FW: Planning Consultation on: AL/20/26/PL - SUB PLAN REQUEST

Subject: RE: Planning Consultation on: AL/20/26/PL

Many thanks for the comments issued on 23.04.2026. Having read your comments, I wanted to take this opportunity to provide you with a response and additional information you have requested, which has been prepared in collaboration with our drainage consultant.

DRAWING TITLE: PROPOSED DRAINAGE LAYOUT

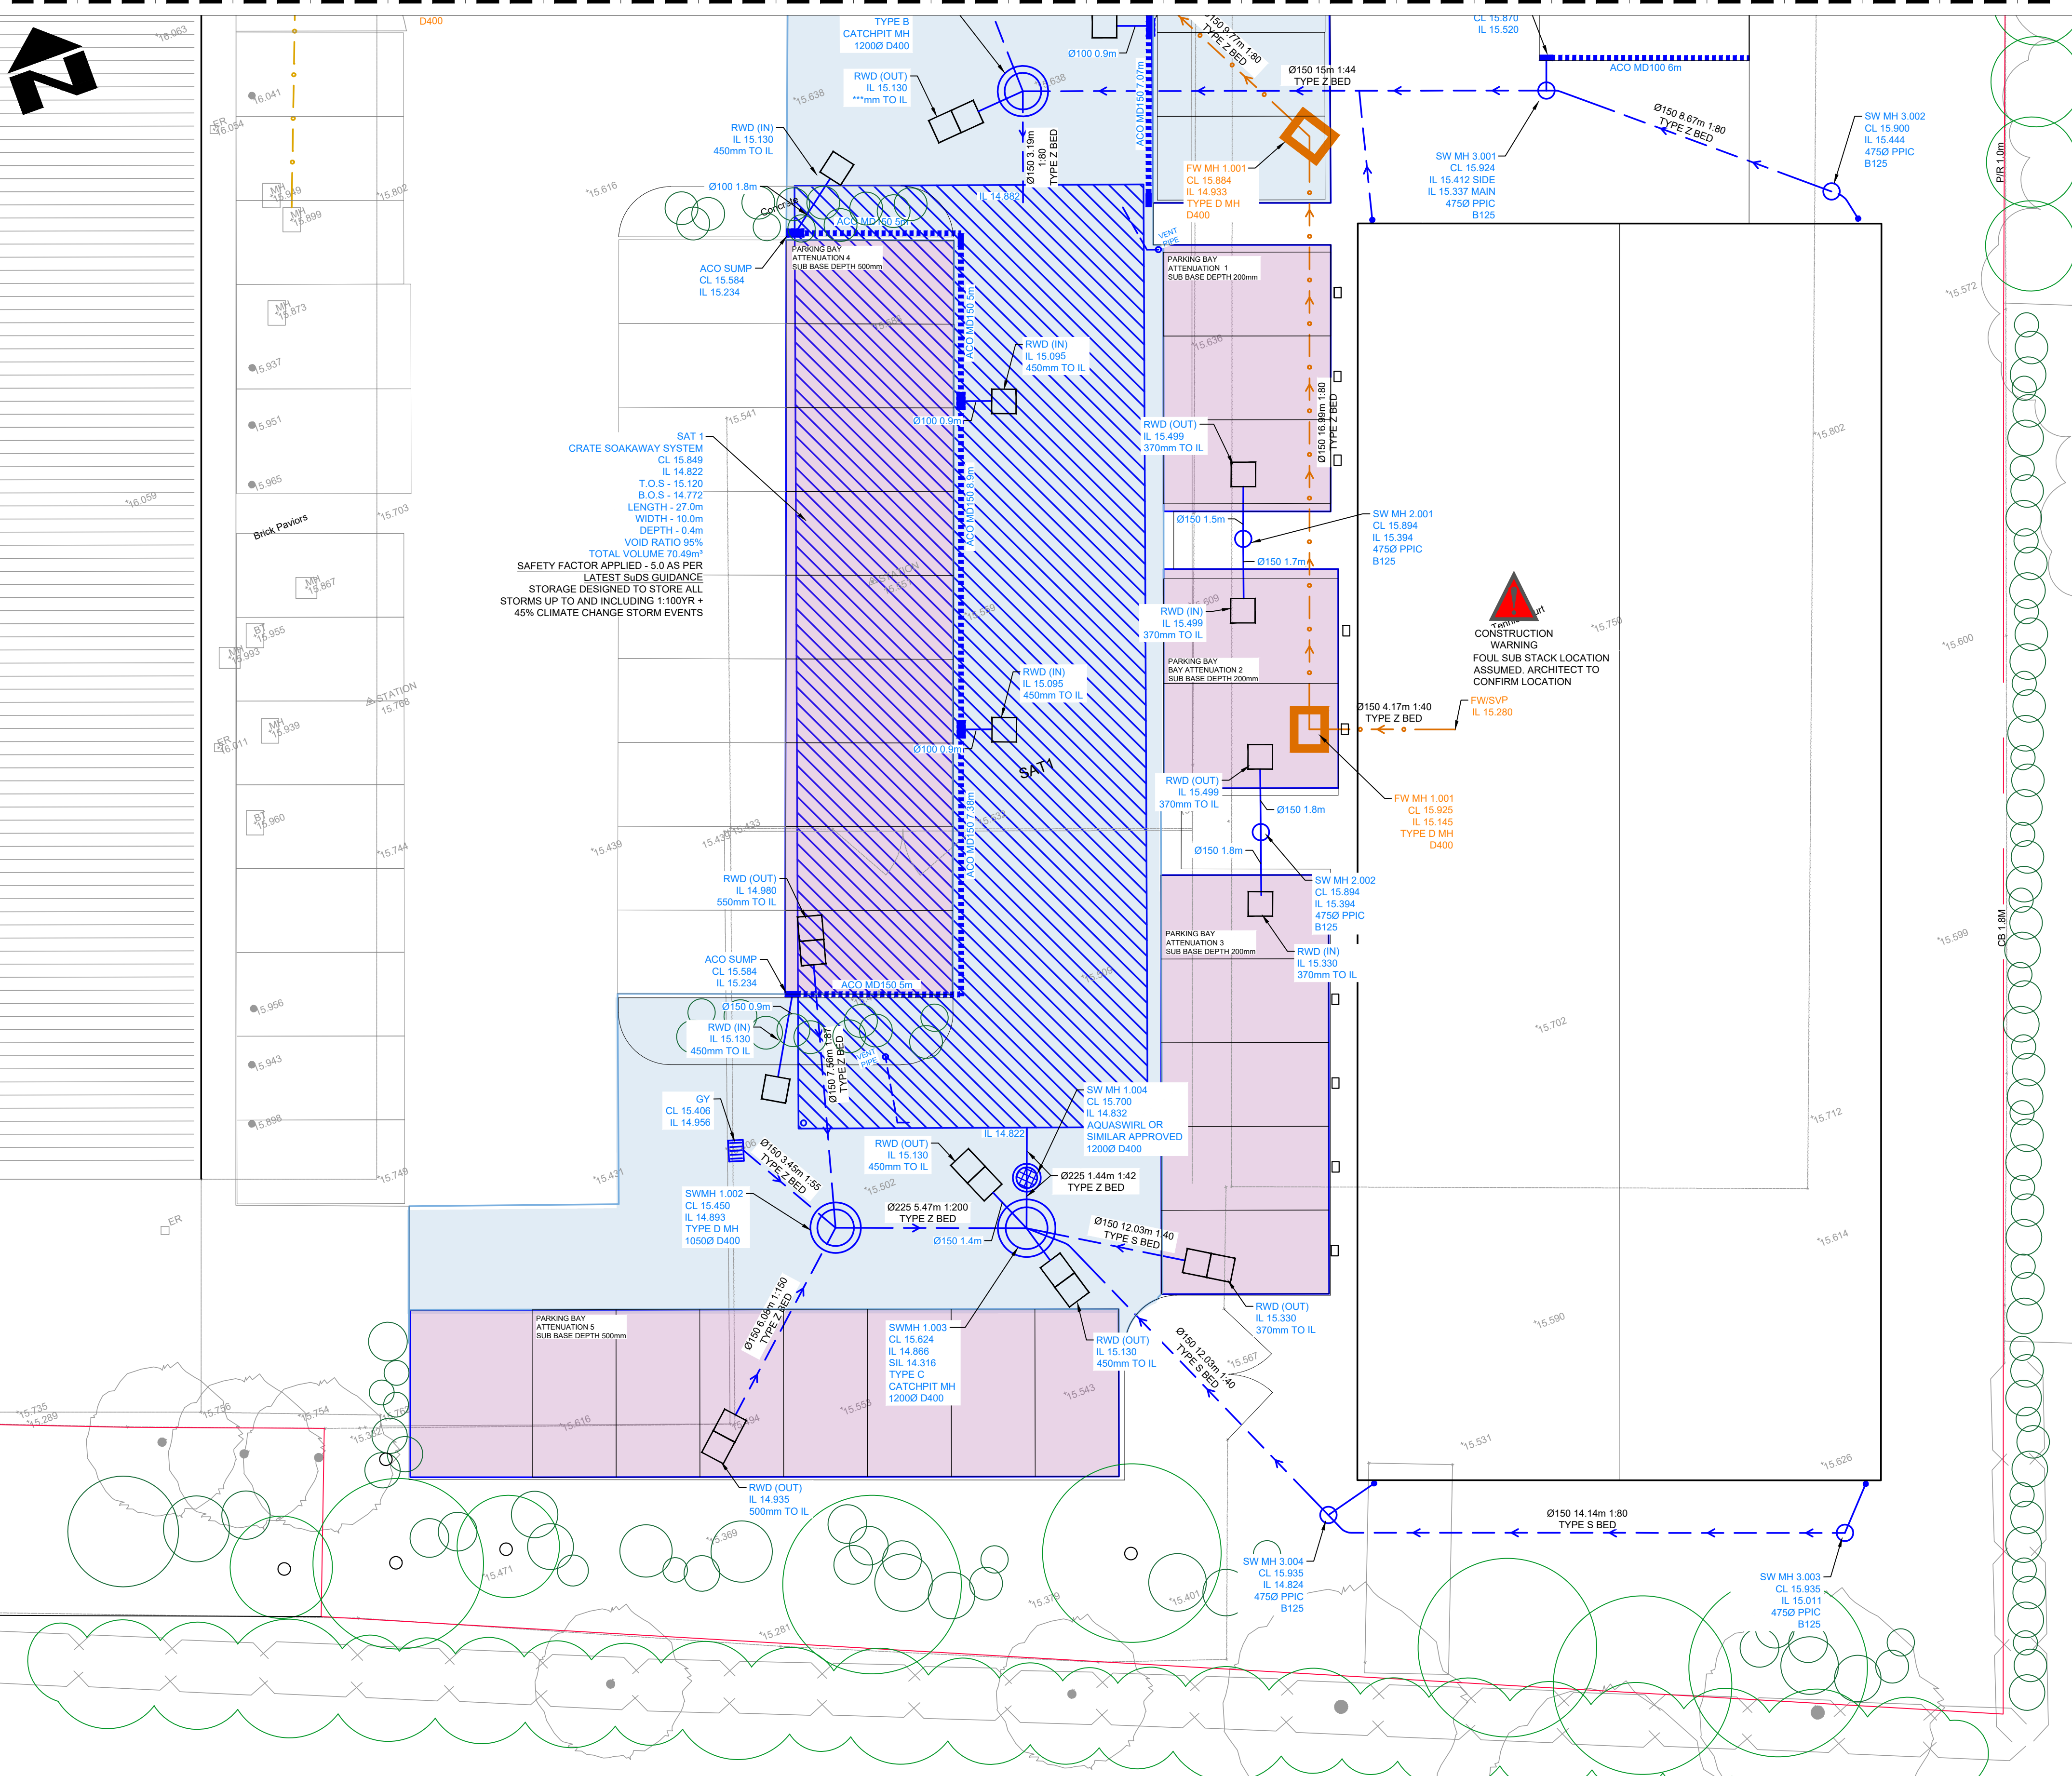
3.2 - 'There are also minimum factors of safety required by the NSfS for infiltration which have not been applied and would increase the size of infiltration system required. Justification of the rate applied should be provided.'

Following a review of the new Suds guidance, the safety factor for the proposed soakaway has been amended from 2.0 to 5.0. This conforms with table S3.1 of the new SuDS guidance. The proposed soakaway has been upsized accordingly to ensure no flooding is present for all storms up to and including the 1:100 yr + 45% climate change storm events. Please find attached the updated drainage plan and hydraulic calculations evidencing the changes.

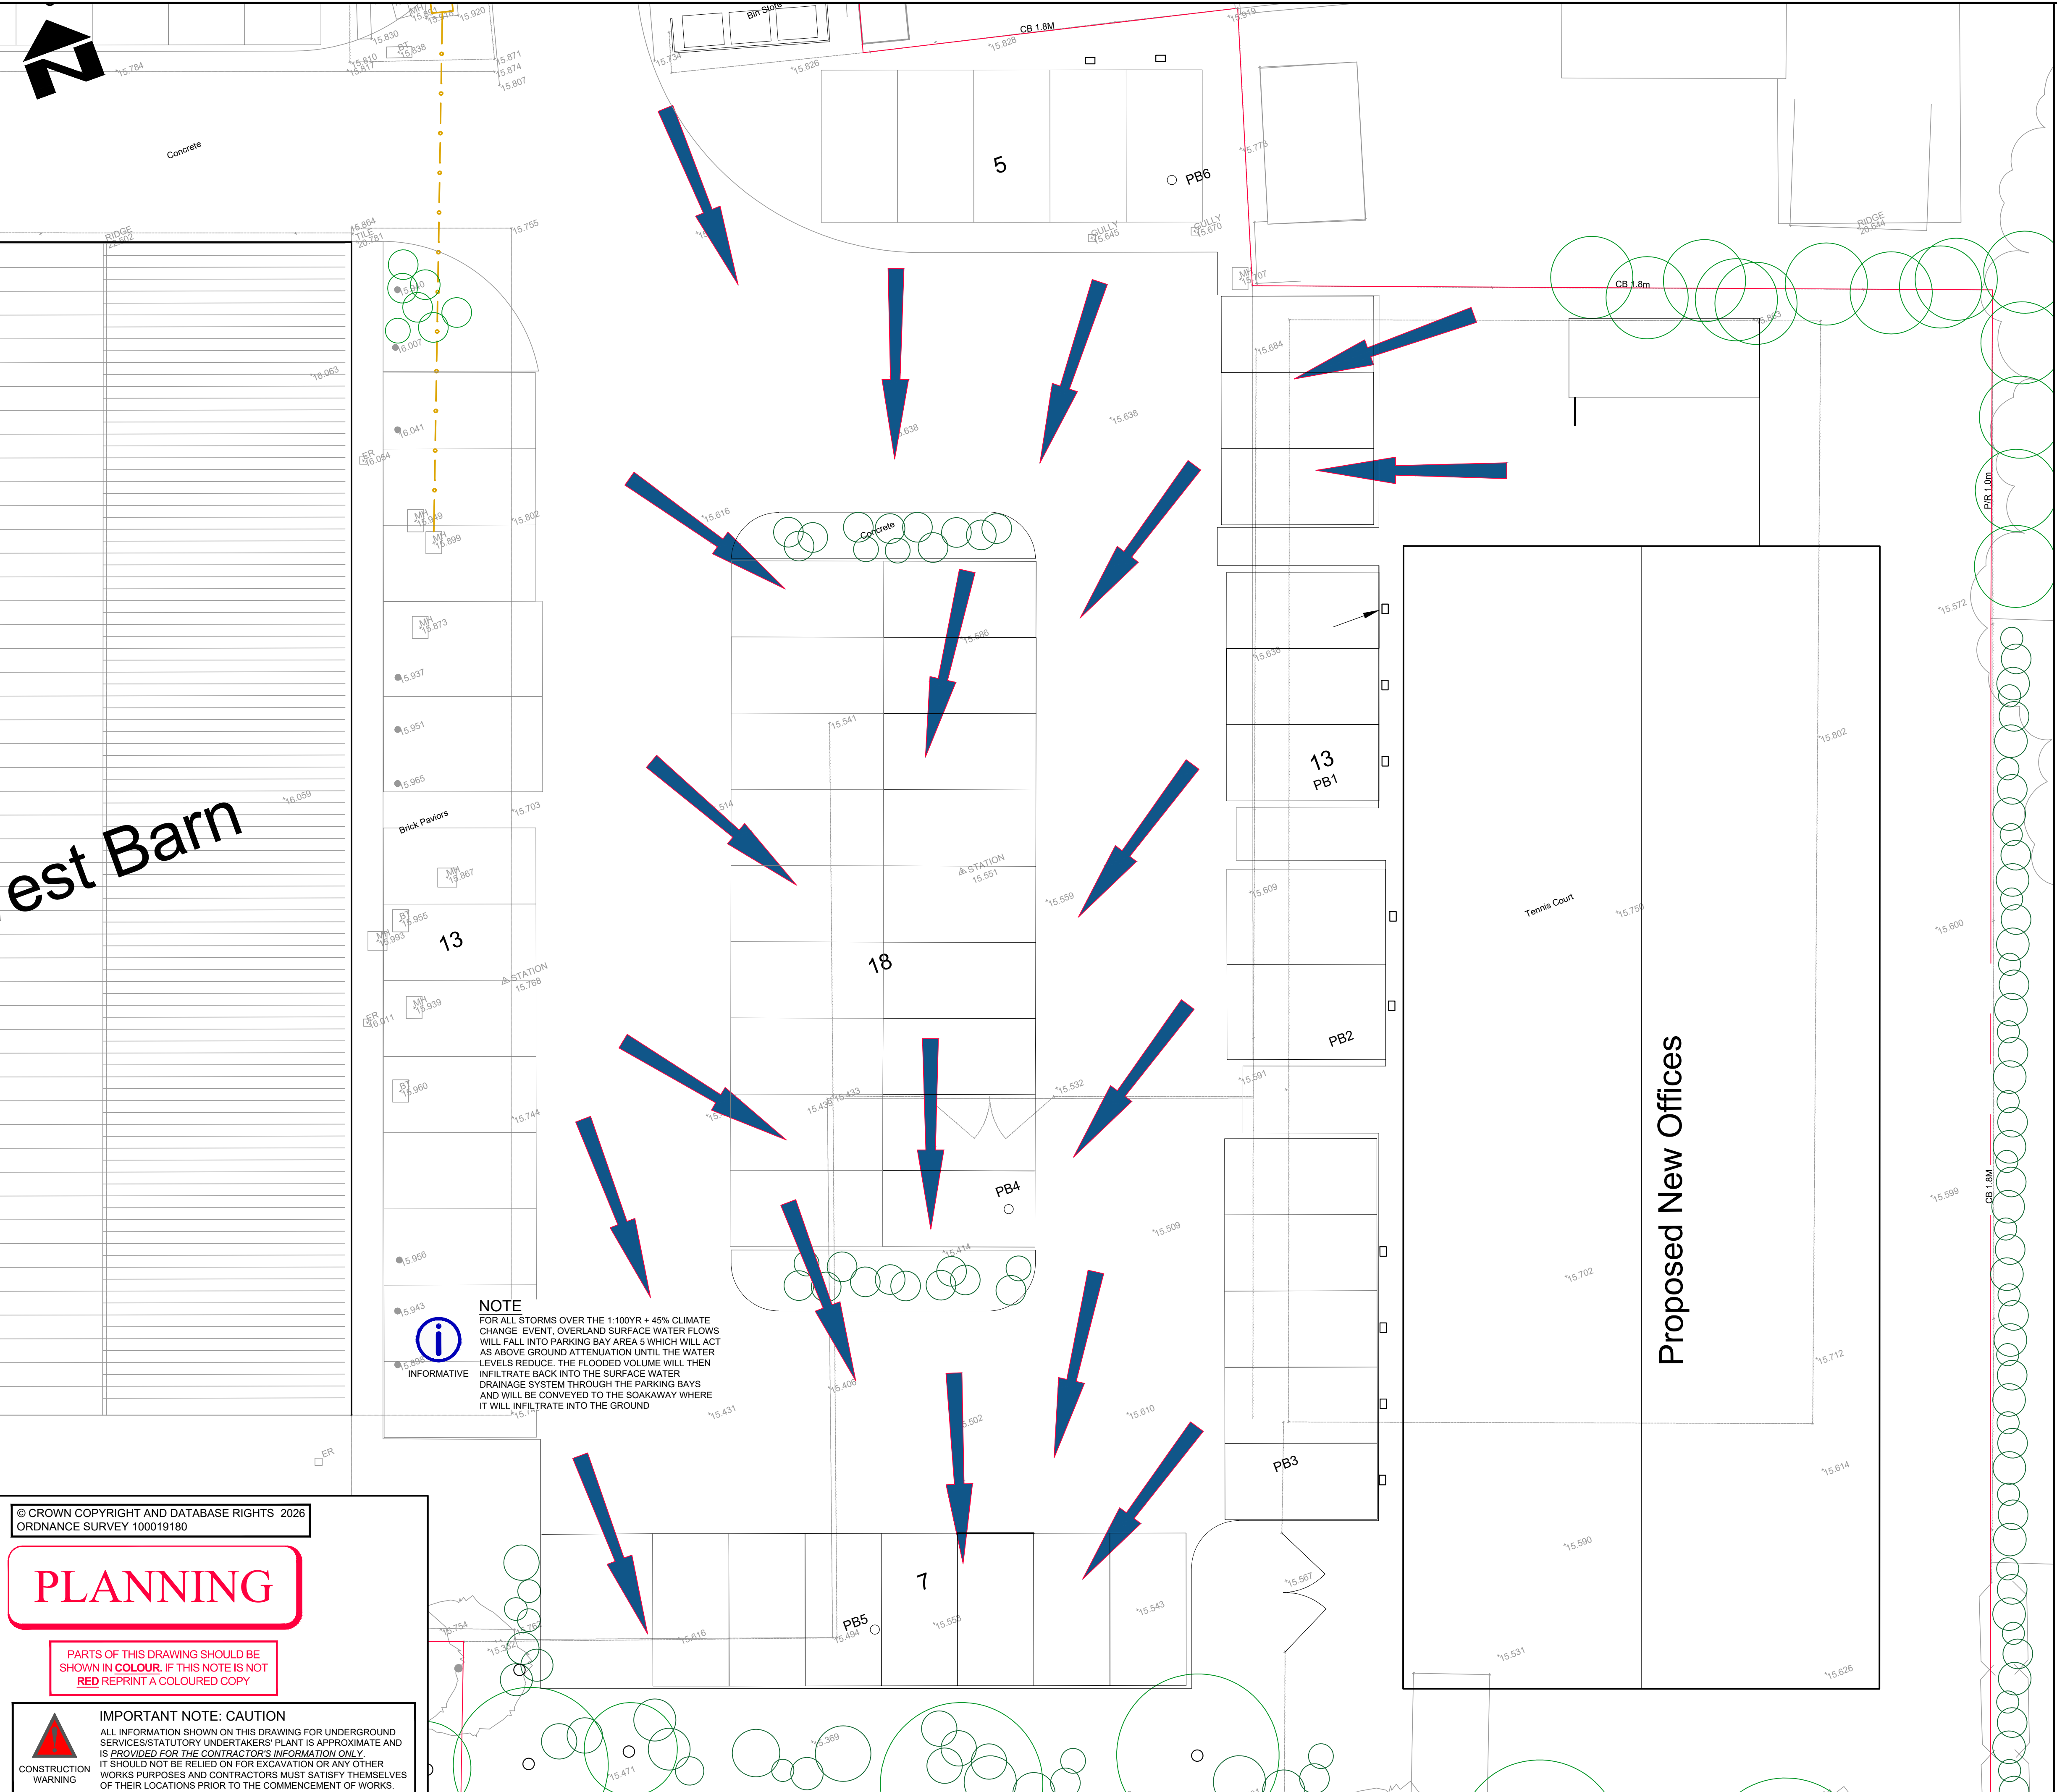
3.1 - 'An impermeable areas plan should be provided to confirm the drained area and audit the modelling inputs. No urban creep is required.'

Please find attached Impermeable Areas Plan as requested.
